Consultation Response from KC, Highways Development Management
2024/91476 Clough Farm, Long Lane, Earlsheaton, Dewsbury, WF12 8LQ
Erection of 20 dwellings and 6 quarter houses
Date Responded: 12-8-2024. Responding Officer: Mark Berry. Responding Ref: 15-5SE-3.
This application seeks approval to the erection of 24 dwellings at Clough Farm, Long Lane, Earlsheaton, Dewsbury. This application includes a similar shared surface carriageway layout and turning head to the 2021 permission on this site with the same point of access onto Long Lane. A 2.0m wide footway is shown to the Long Lane site frontage. A 2.0m wide footway is also shown to run from Long Lane and along the southern side of the proposed estate road. The proposed dwellings include 20 type C and E three bedroomed dwellings in blocks of two and three two pairs of semi-detached one bedroomed bungalows. The three bedroomed units are all shown to have 2 off-street parking spaces and the one bedroomed units are all shown to have one off-street parking space plus two private visitor parking spaces. A further 4 visitor parking spaces are shown at the end of the propose shared surface carriageway adjacent to plot 12. The site has a

Project: **LONG LANE**
Earlsheaton, Dewsbury
Drawing Title: Proposed Site Plan
Scale: As shown
Drwg. Created: 28.02.2024

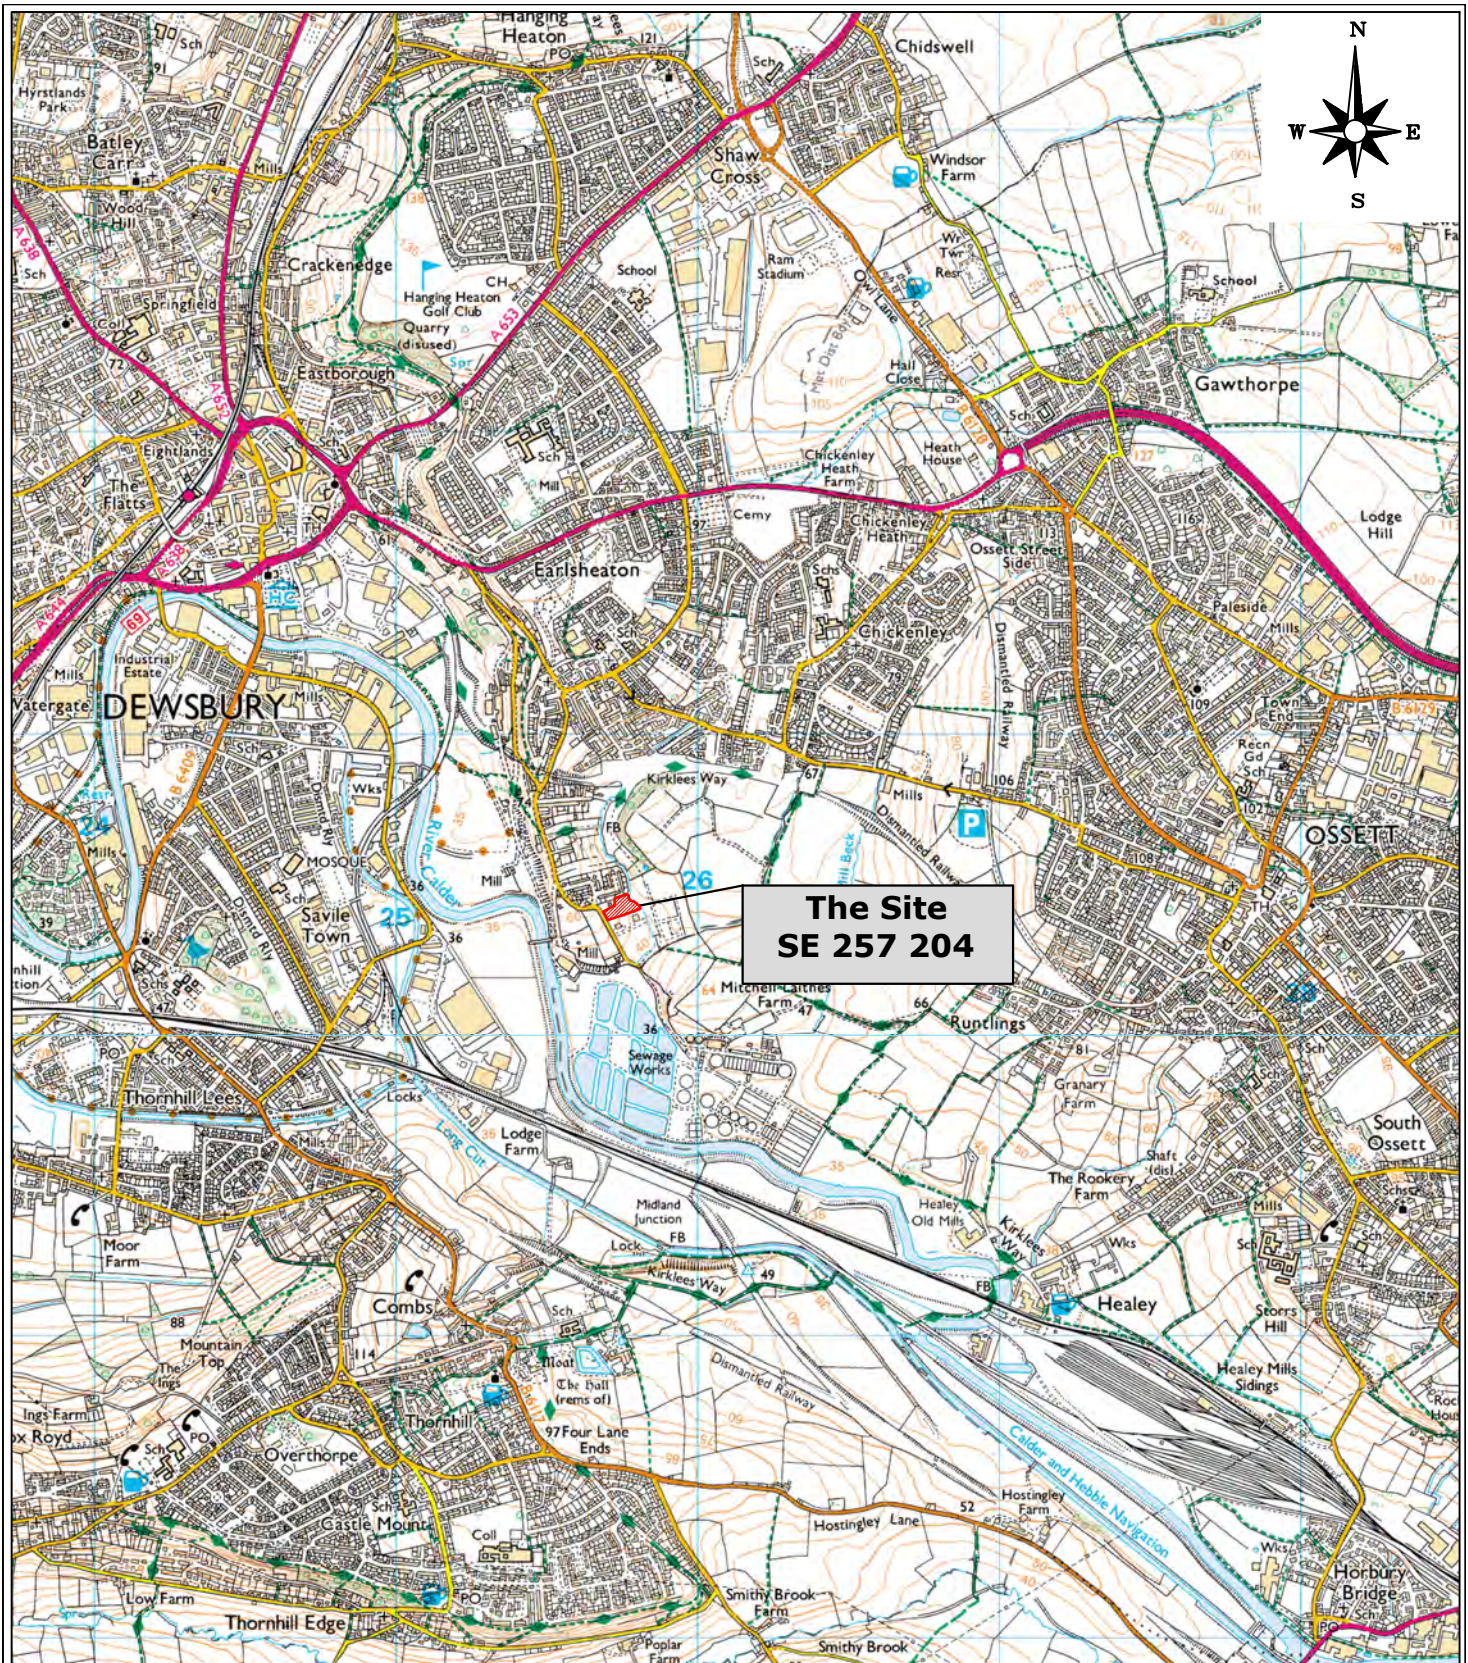
on collection day without either obstructing the highway or proposed driveways.

3, The extent of the proposed adoptable highway is not clear. The applicants need to clarify the extent of adoptable highway noting that the maximum number of dwellings that can be served by a private drive is 5.

4, Visitor parking should be provided at a rate of 1 space per 4 dwellings or 6 spaces for the 24-dwelling proposed. Where on-street parking is envisaged, swept path analysis is required to demonstrate if the Kirklees Refuse Vehicle can manoeuvre through. The visitor parking shown is within private areas and is not spread evening across the site.

5, Sight lines are not shown at the site access onto Long Lane.

6, Forward visibility splays should be shown across the bend in the proposed road and sight lines at the junction of the two internal roads.

7, The footway across the access to plot 21 needs to continue through has a dropped crossing and not retuned into the proposed driveway as shown.
